**WEST SUSSEX COUNTY COUNCIL
STRATEGIC PLANNING CONSULTATION**

SUBJECT: EP/55/12 - 1 x new dwelling

Land Adj to, 20, Eastern Close, East Preston, West Sussex, BN16 1BS

Site Plan (existing)
scale 1:500 @ A3

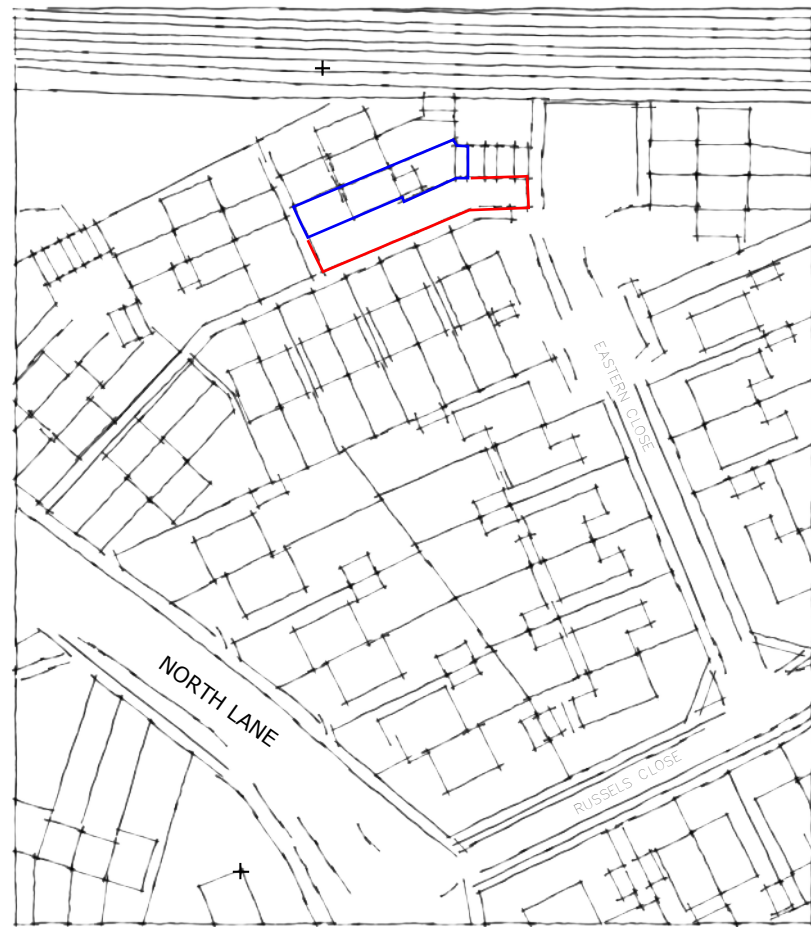
From an inspection of the plans alone it would seem visibility is limited when reversing on to the highway due to the 1.8 metre boundary fence. As there is an adjoining footway to the site, pedestrian visibility splays of 2 x 2 metres with no obstructions over 600mm for the first 4 metres of the boundary fence (or up to the garden perimeter) should be added to any planning consent.

The new dwelling does not provide any turning on-site for parked vehicles, however, the lack of a turn-on-site would not be anticipated to have a detrimental impact on highway safety given that the area is situated at the end of a cul-de-sac with limited traffic movement occurring. The most recently verified accident records reveal there have been no RTA's in the vicinity of the site. The amount of off-street parking is within WSCC's adopted standards.

In summary, WSCC does not anticipate that this proposal would have a negative impact on highway safety in this location. WSCC would recommend, however, that the LPA attach conditions regarding cycle parking and pedestrian visibility with respect to this application. WSCC can advise on the appropriate wording for these conditions if required.
